REQUEST

Current Zoning: NC (neighborhood center)
Proposed Zoning: MUDD-O (mixed use development, optional)

Approximately 0.94 acres located at the southeast intersection of Commonwealth Avenue and The Plaza, north of East Independence Boulevard.

**STAFF
RECOMMENDATION**

RZ-1

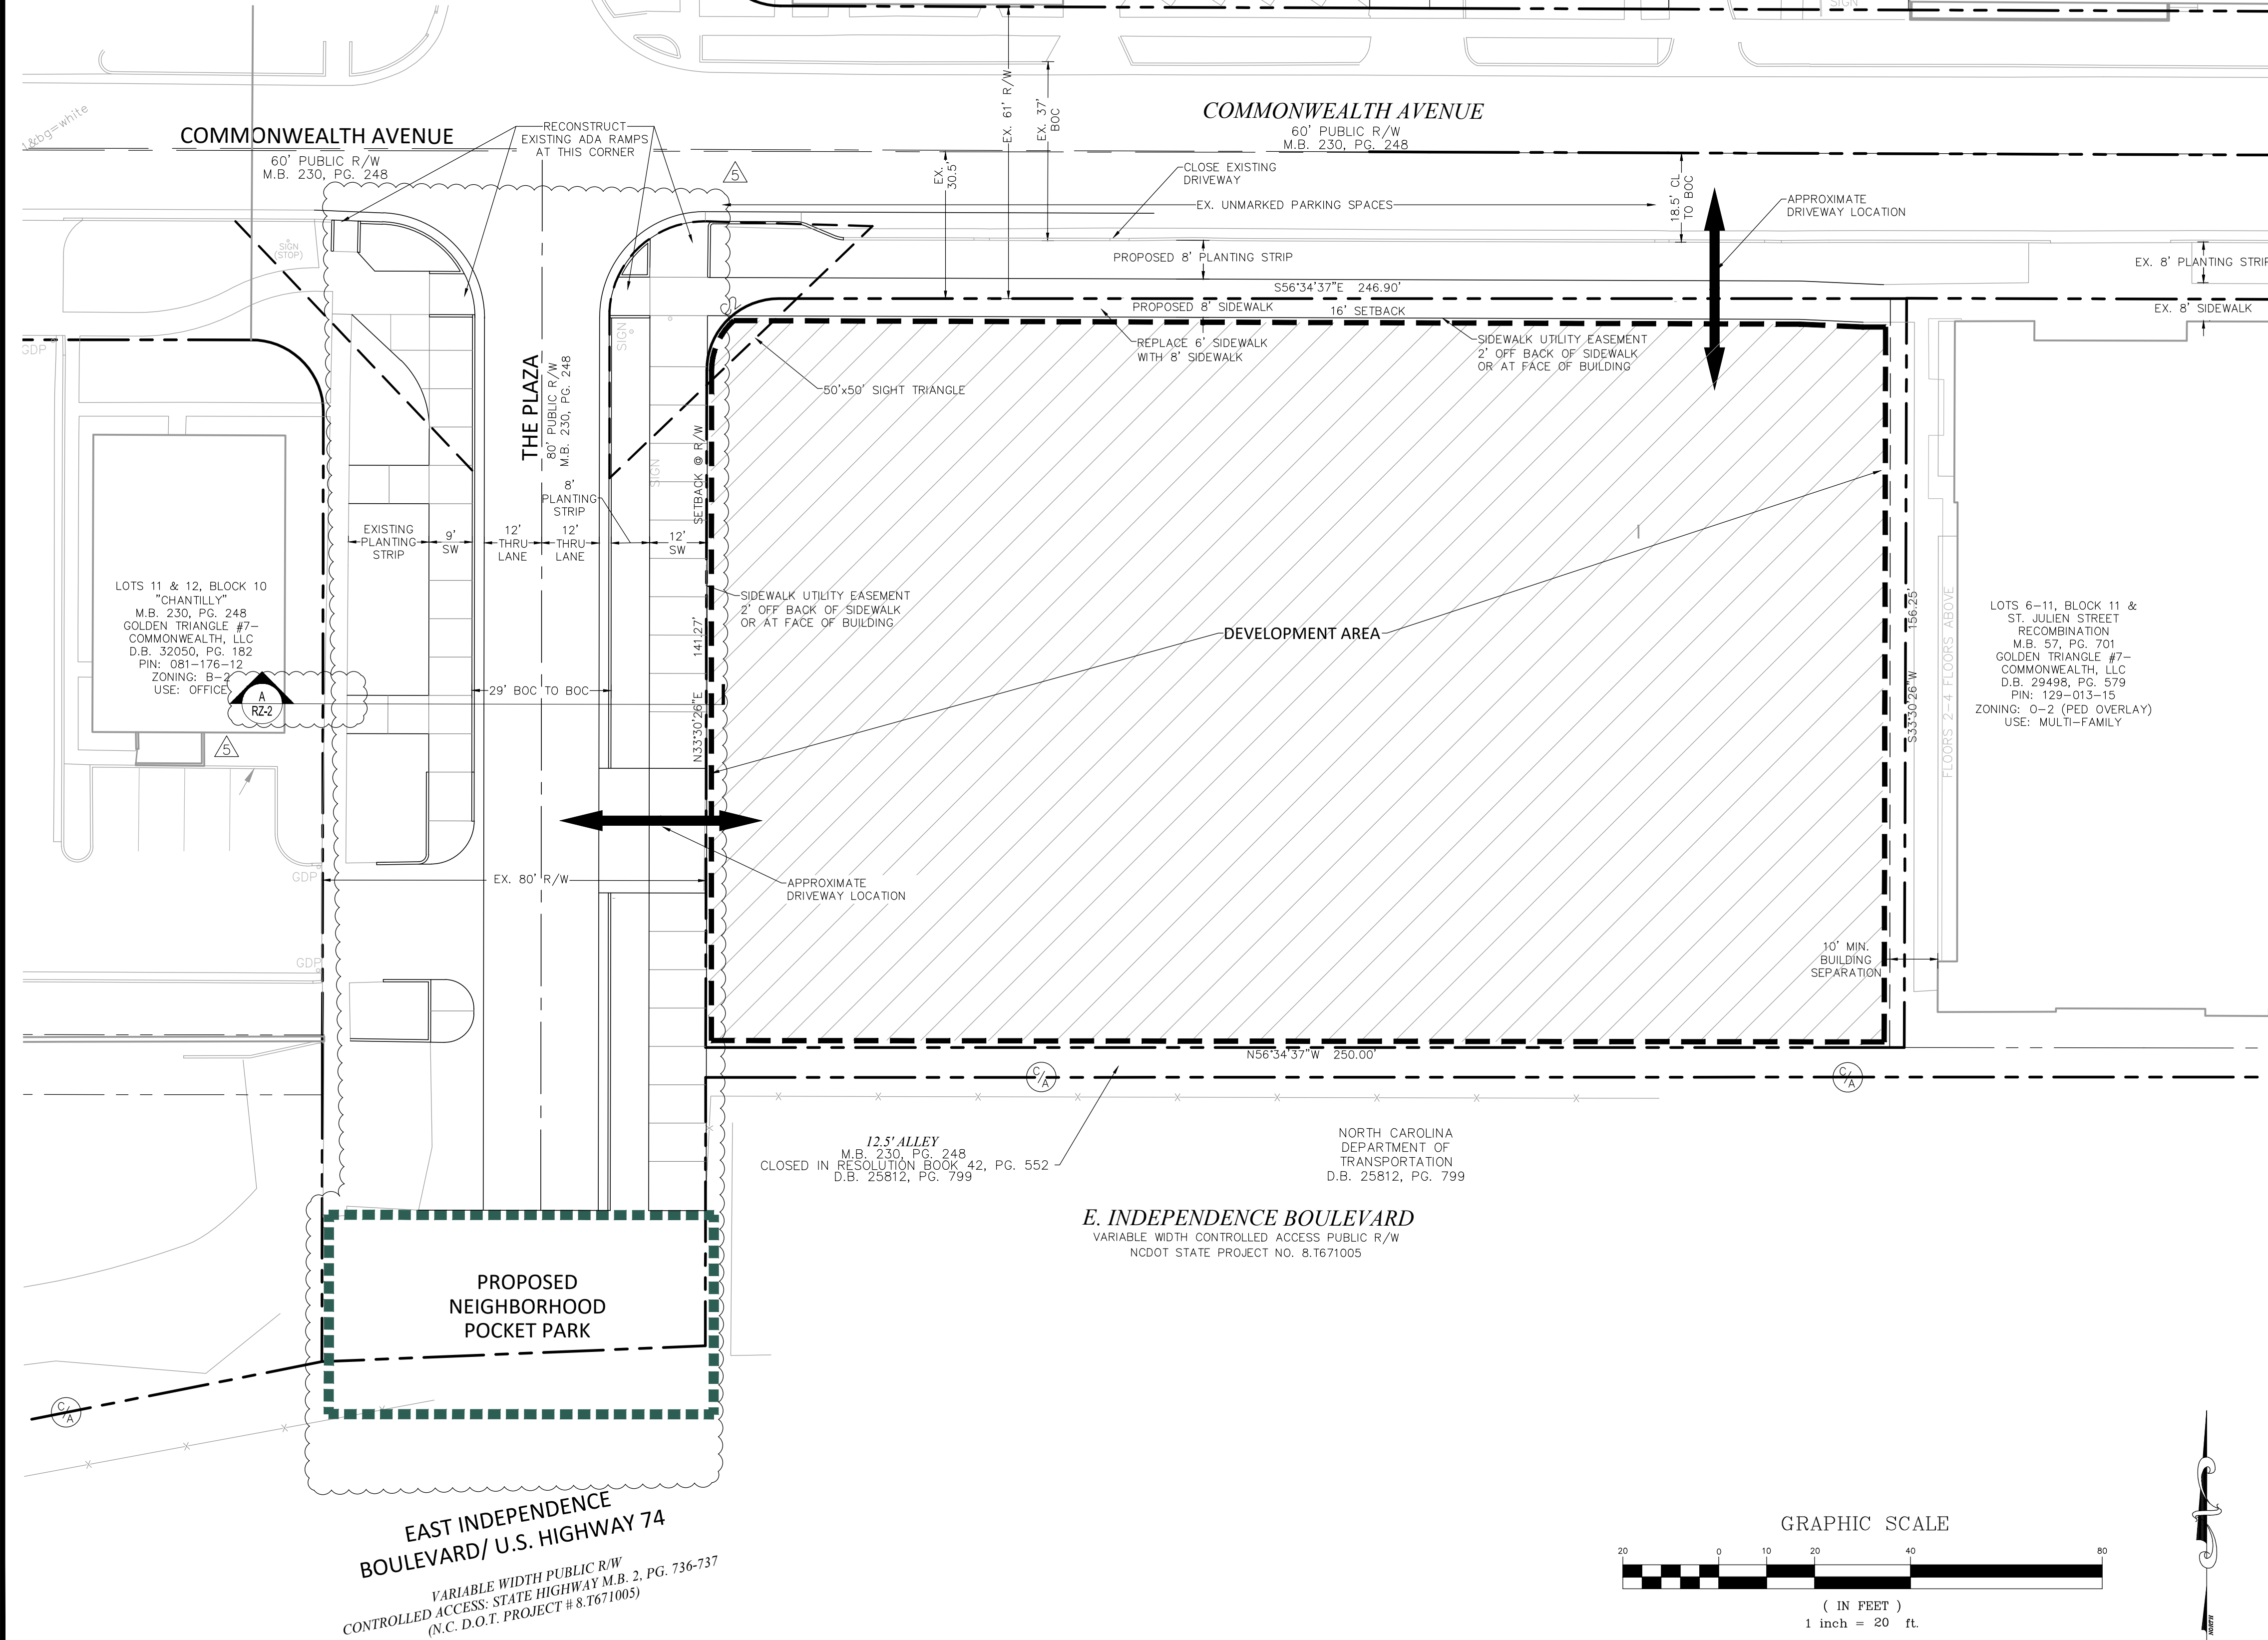
1. Show required right-of-way trees.

PROPOSED CROSS SECTION - THE PLAZA
SCALE: 1" = 5'

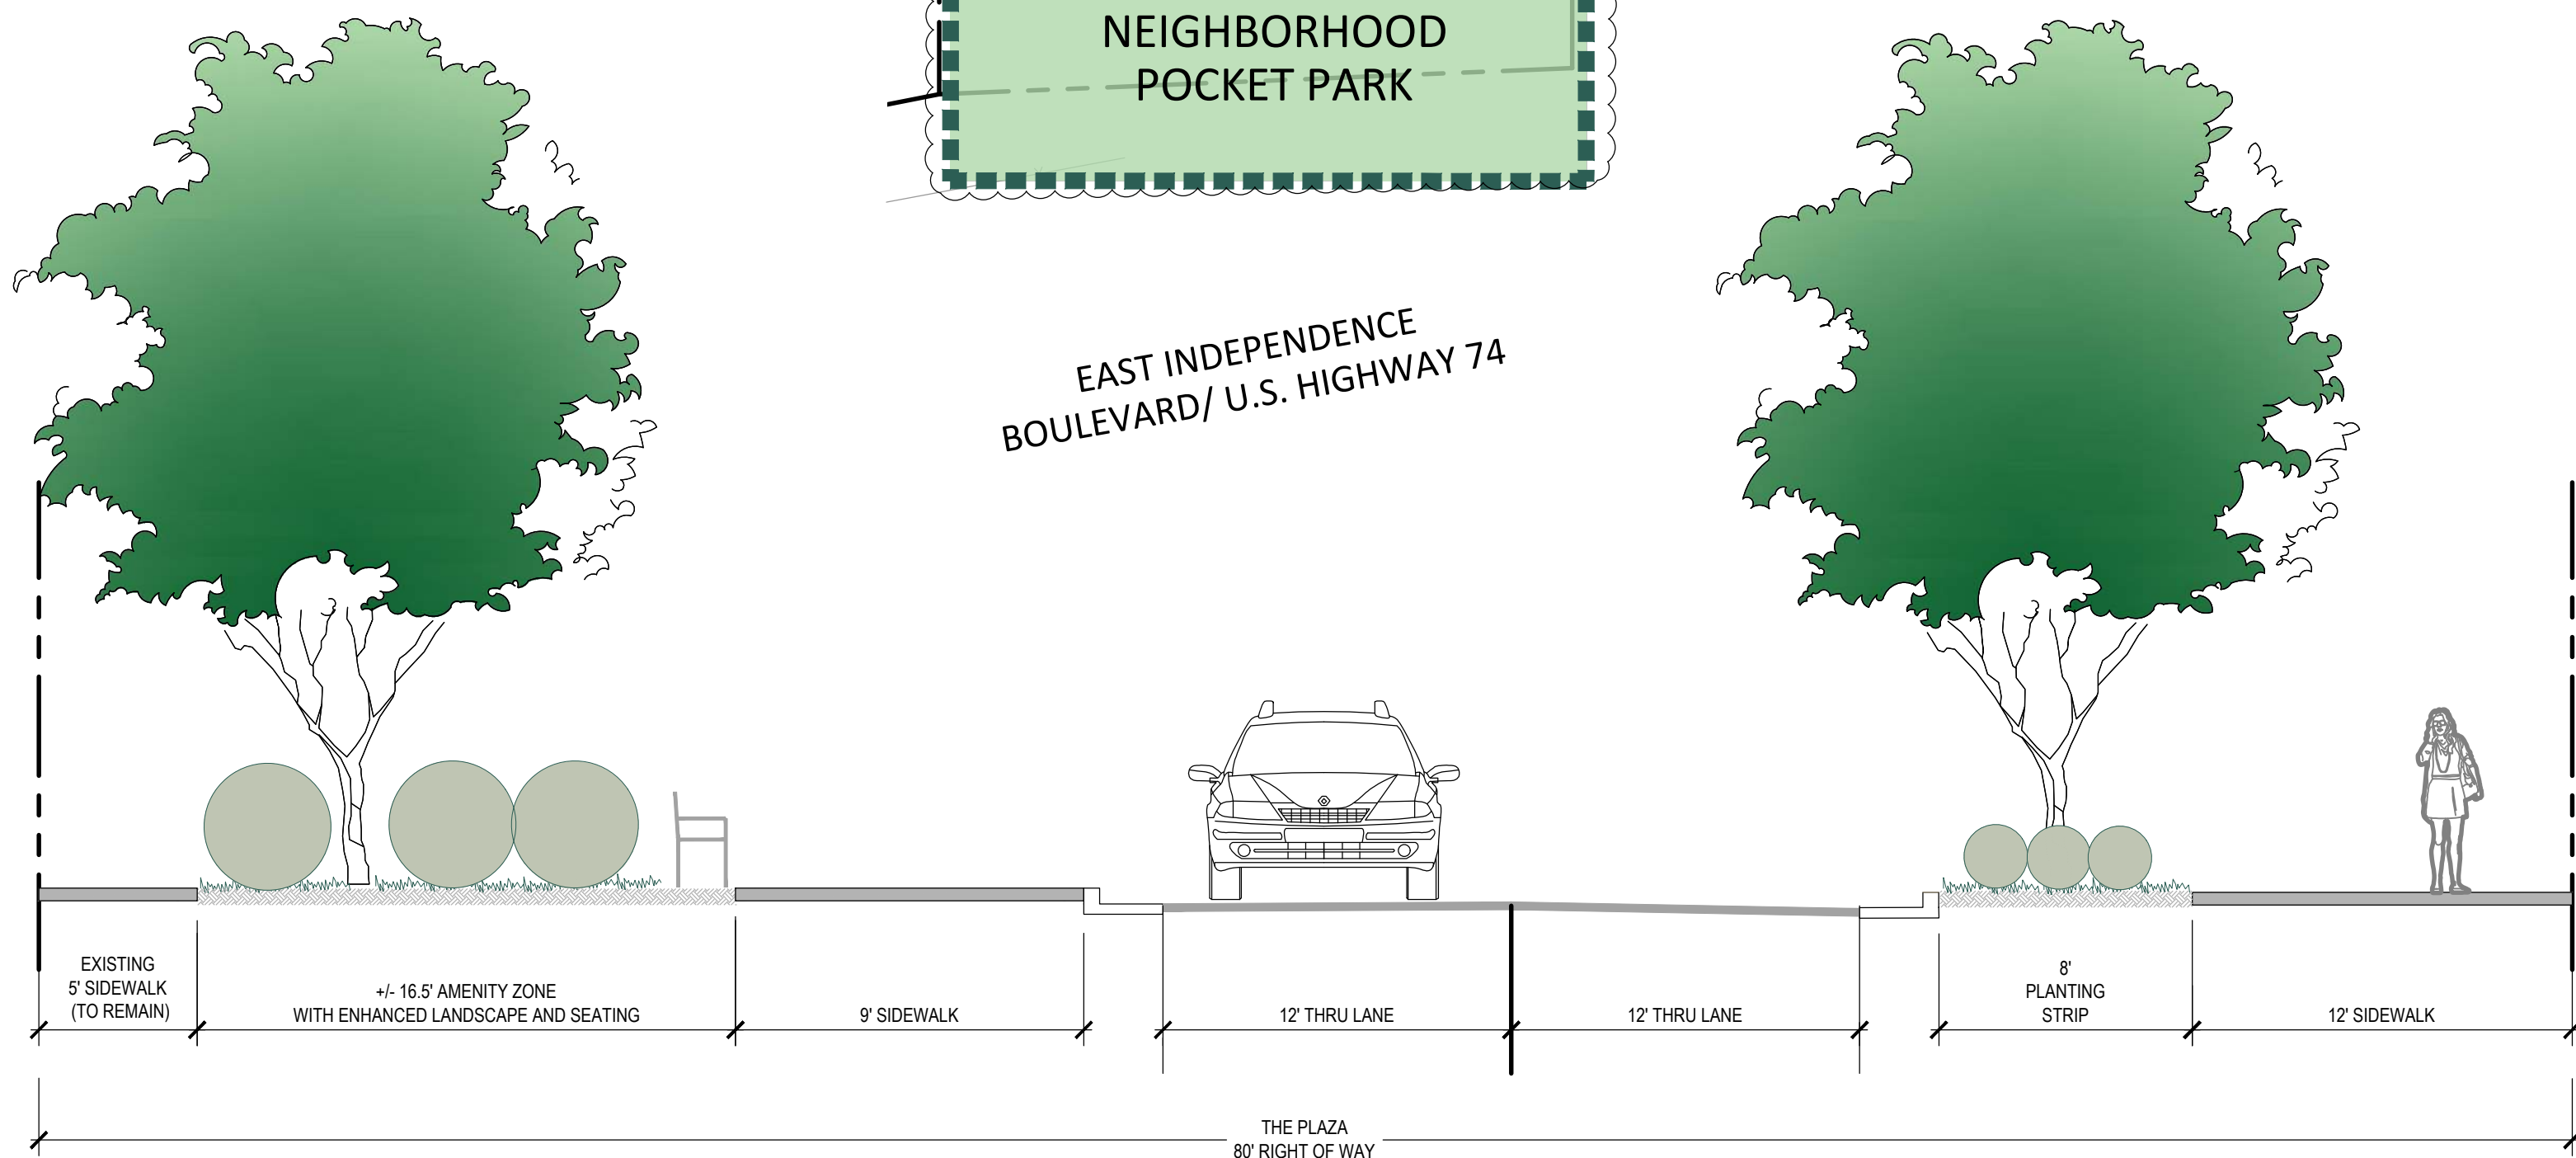
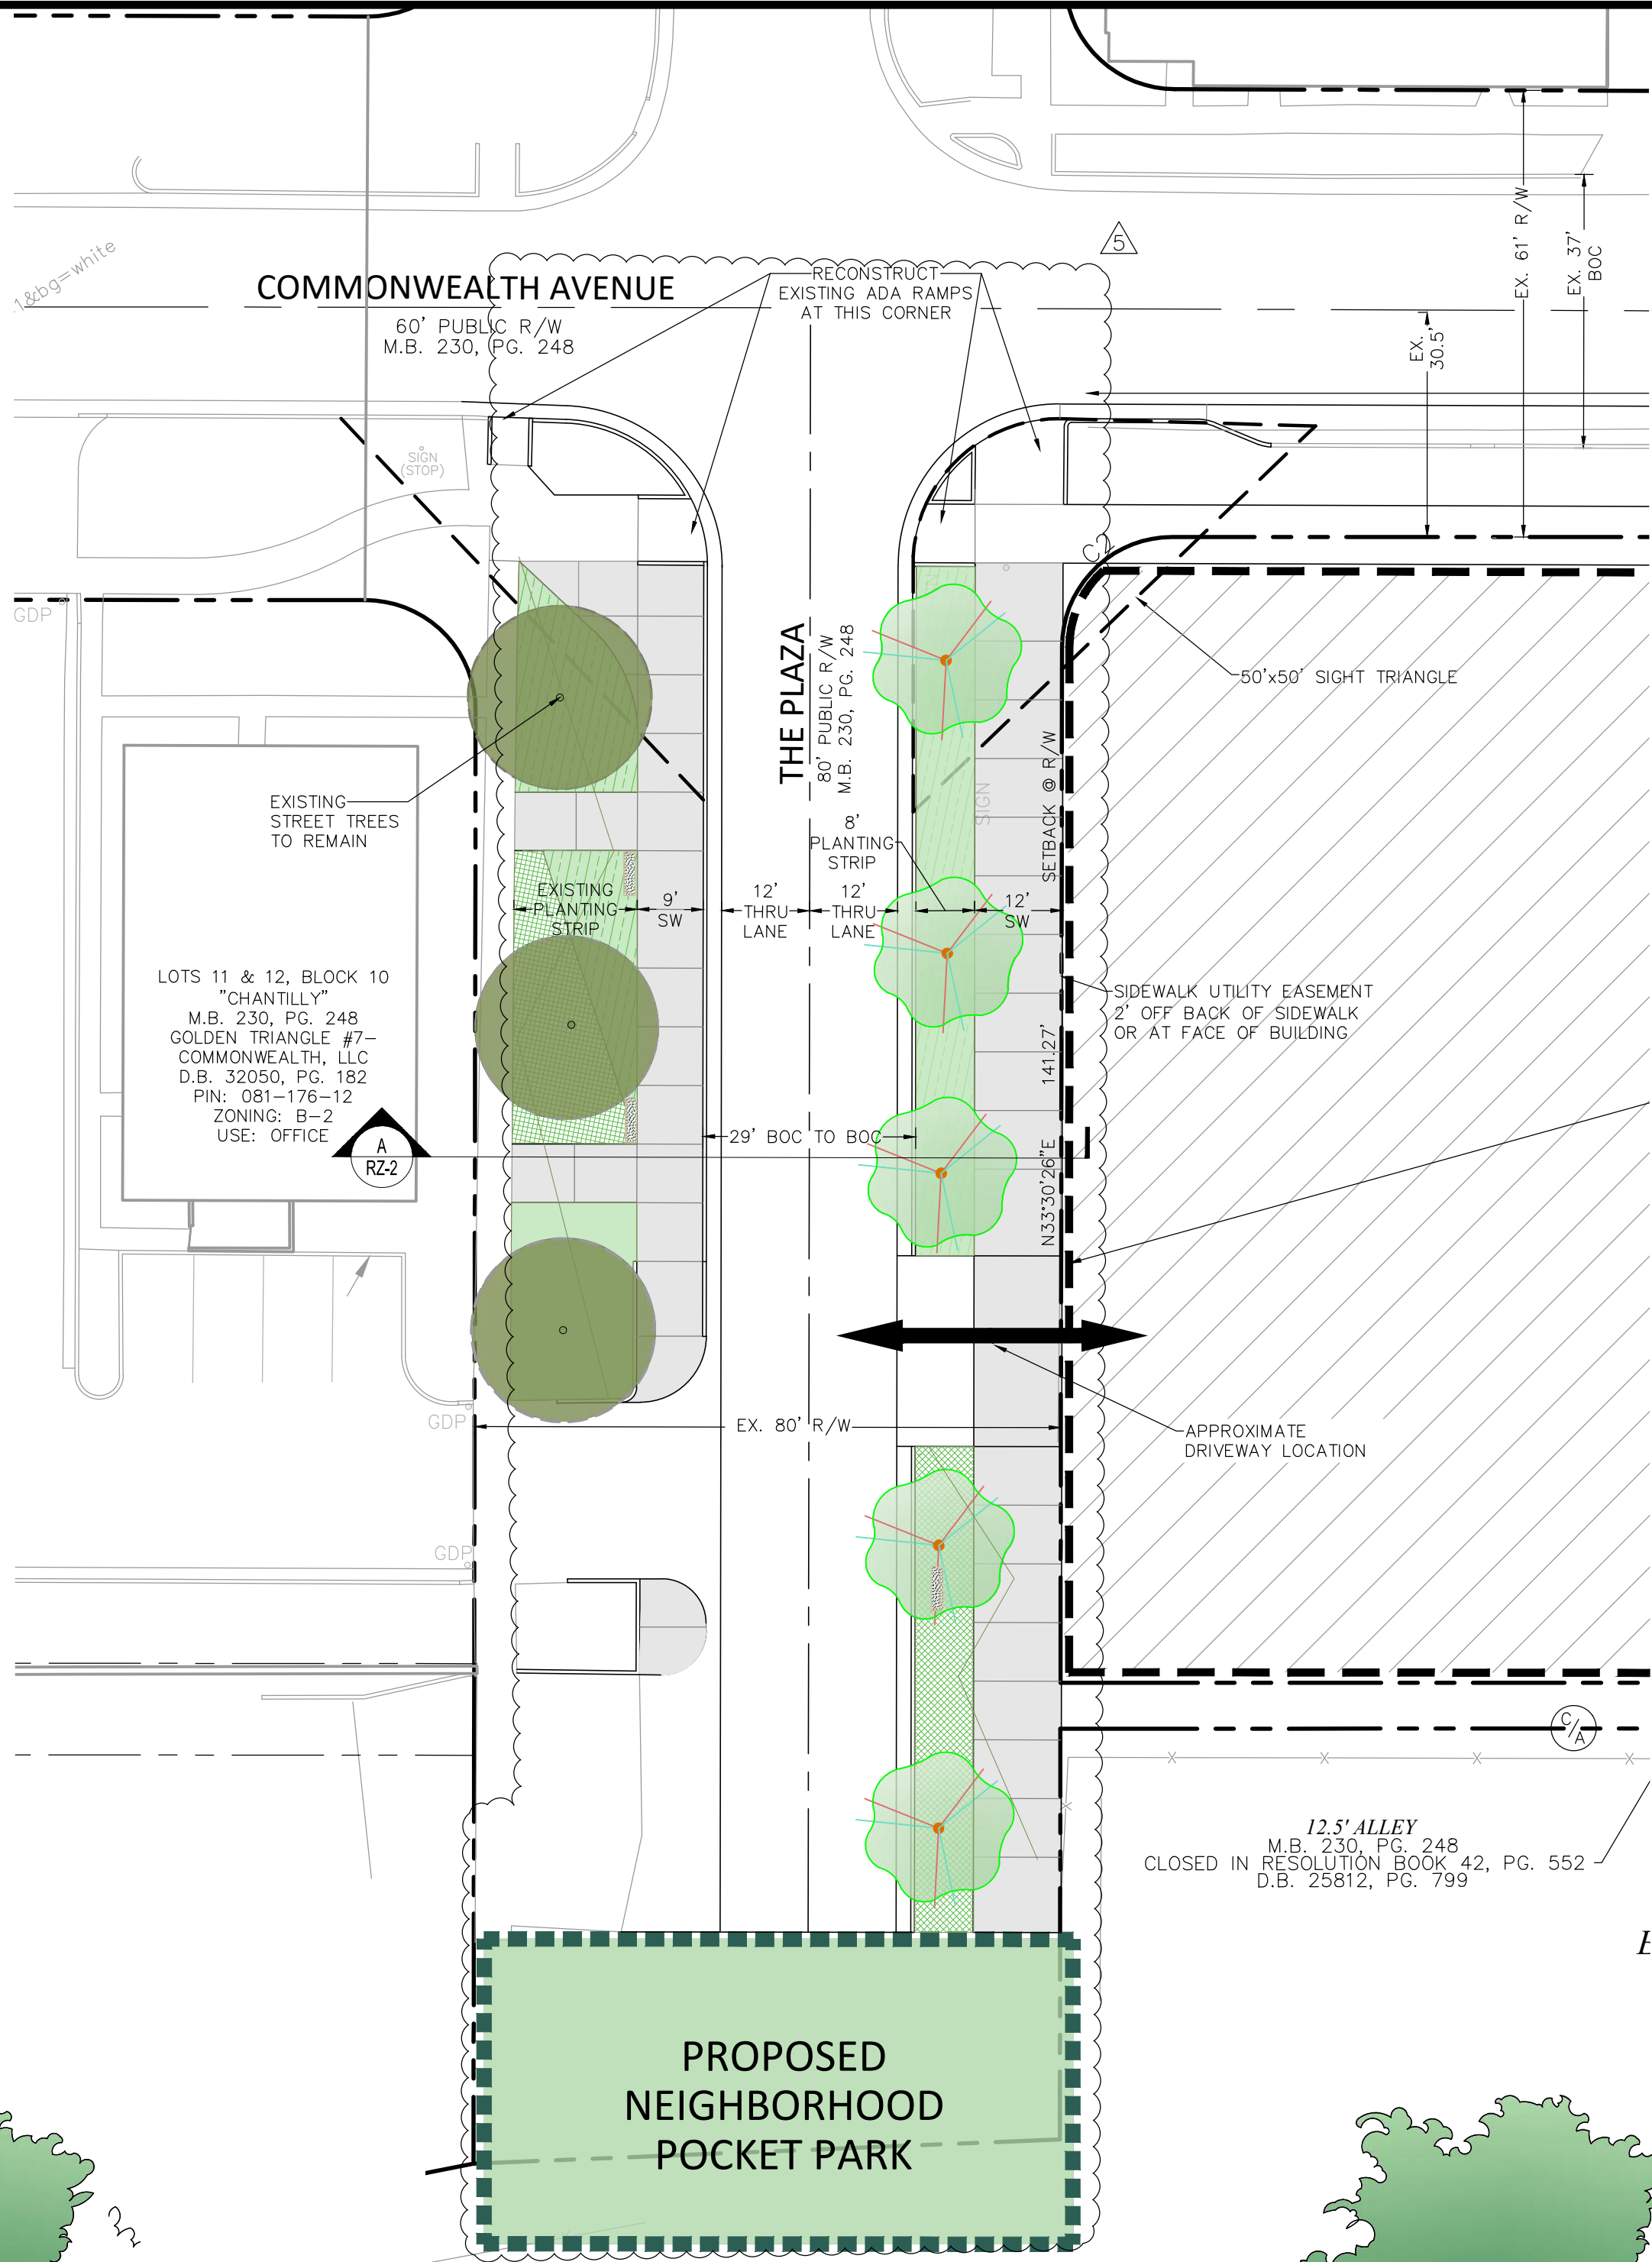
2. The back of curb sidewalk shown is not acceptable to CDOT, remove from plan. Based on the context of the street CDOT can consider a local office/commercial wide with parallel parking and curb bumpouts per CLDSM U-05, with amenity zone instead of planting strip. In addition, remove proposed park – park not allowed in right-of-way.
